In addition to responding to DPIE's RFI's in the letter of 08.06.21, this RTS includes a request for a plan swap to provide updated office elevations for warehouses 2A, 2C & 2D.

### 1. RFI response to DPIE's letter of 08.06.21

A) Response to DPIE's queries of Attachment 1, letter 08.06.21:

1 ELEVATION WEST - WAREHOUSE 2C 1 : 250

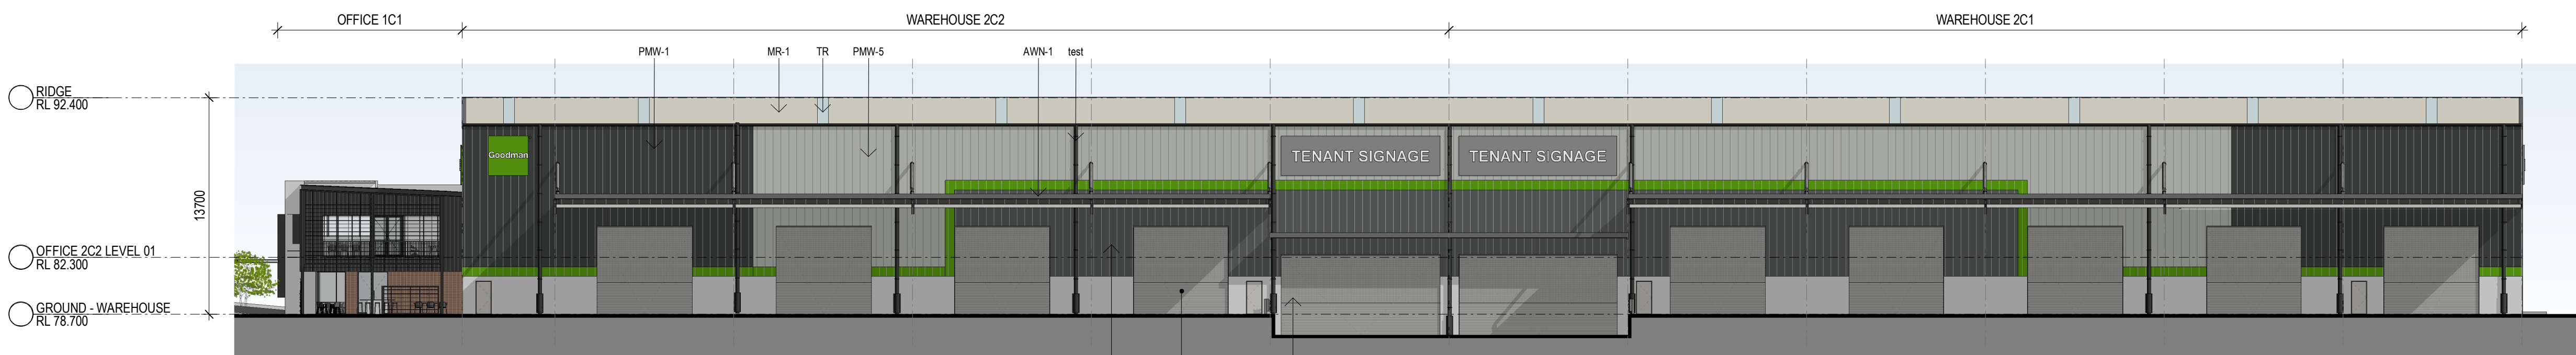
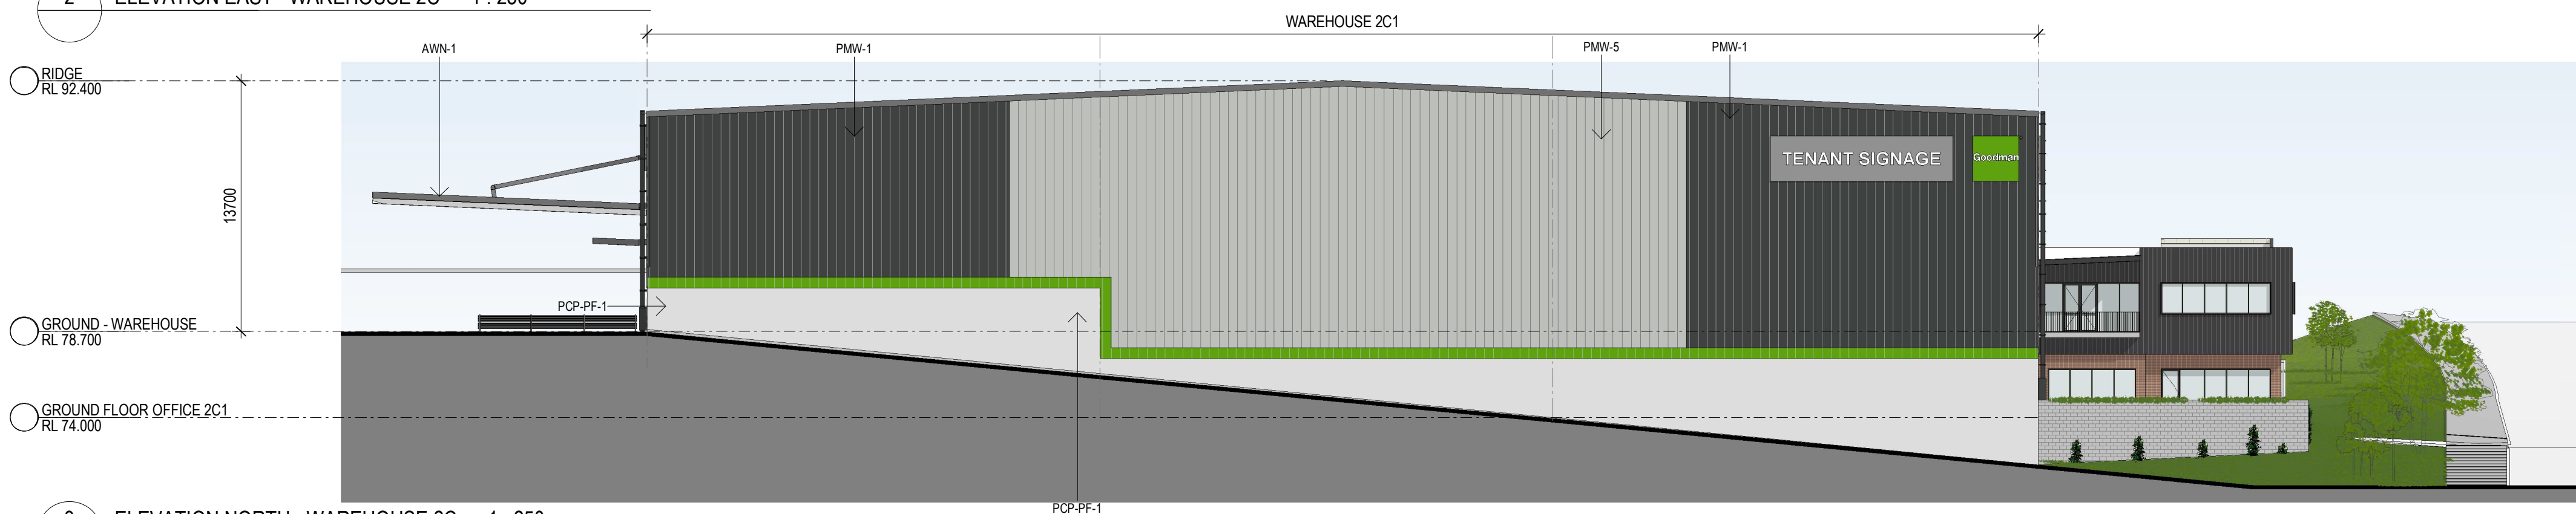
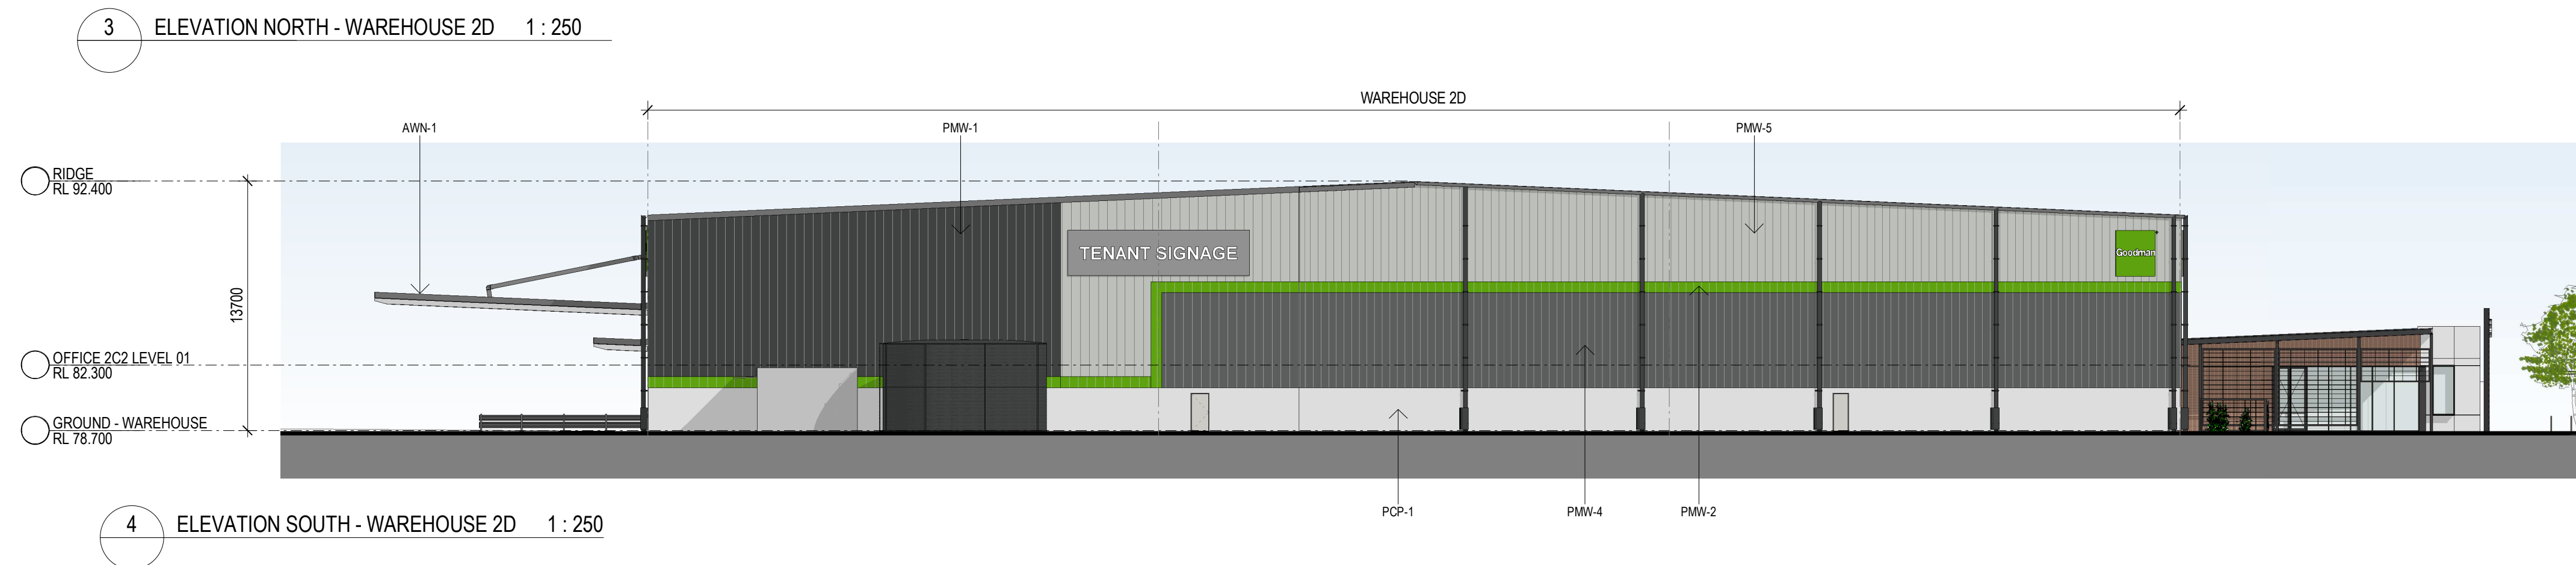
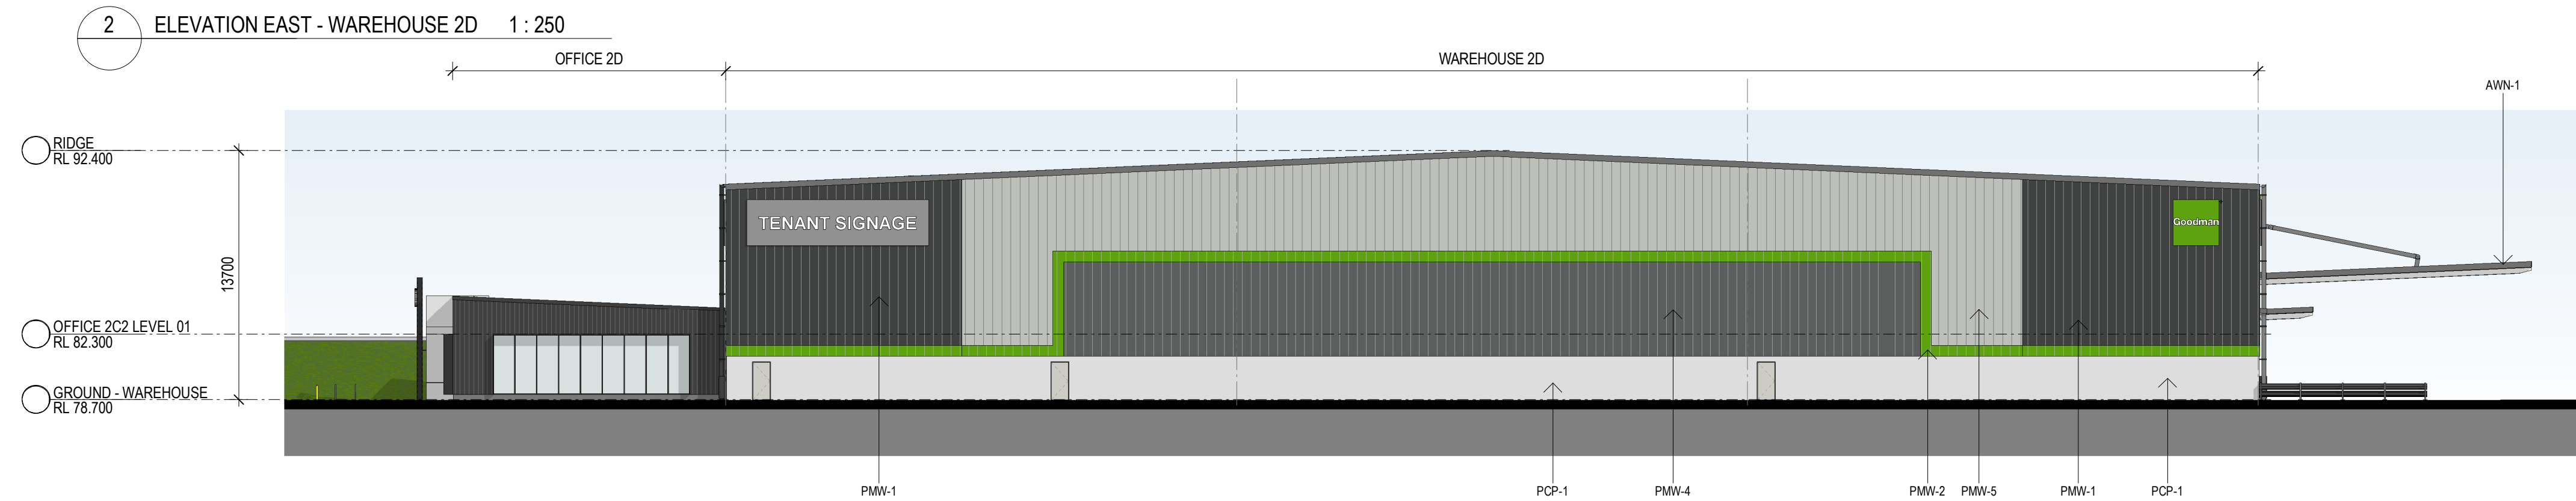
The Department notes that the effective height of Building 2C is approximately 22.2 m, which exceeds the 15 m limit in the Oakdale West Estate Development Control Plan (OWEDCP). Please provide justification for the non-compliance or amend the building design to achieve compliance with the OWE DCP.

- It's acknowledged that while warehouse 2C presents as 13.7m from the eastern and southern elevations, from the northern and western elevations there are portions of the façade that present as up to 22m in height. This is primarily due to the sloping nature of the land for Lot 2C between 0 and 8m from east to west.

- It is confirmed that the warehouse ridge height of Building 2C is 13.7m. This measurement is taken from the The building height is appropriate calculated from the approved pad level, considered the 'natural ground level'. From this calculation the warehouse has an effective height of 13.7m and is therefore below the 15m height limit and compliant with the height control and consistent with how the heights of other warehouses at Oakdale West have been measured.

- It is noted that the proposed design prefers a gentle slope / batter from warehouse 2C to Estate Road 03 rather than an aggressive retaining wall right on the boundary of Estate Road 03. The base of the warehouse 2C below the 13.7m on the northern and western elevations are considered 'retaining walls'. This accounts for the portion of the building that is perceived to be over 13.7m of height, and accounts for the increased perception of building height, bulk and scale.

- The architecture plans have been updated to articulate the northern and western elevations to reduce the appearance of bulk and scale. The amended design minimises the bulk and scale of the building by carrying the building façade treatment to a lower level to provide an appearance of a reduced height retaining wall.
- A photomontage (See **Appendix B**) has been prepared which demonstrates that the proposed landscaping will provide good visual buffering and will reduce the appearance of bulk and scale from the internal Estate Road 03.
- It is noted that compared to the approved Lot 1A and Lot 2B warehouses, with heights of 36m and 26m respectively (excluding solar), the height range of Warehouse 2C between 13.7m - 22m will appear recessive by comparison.
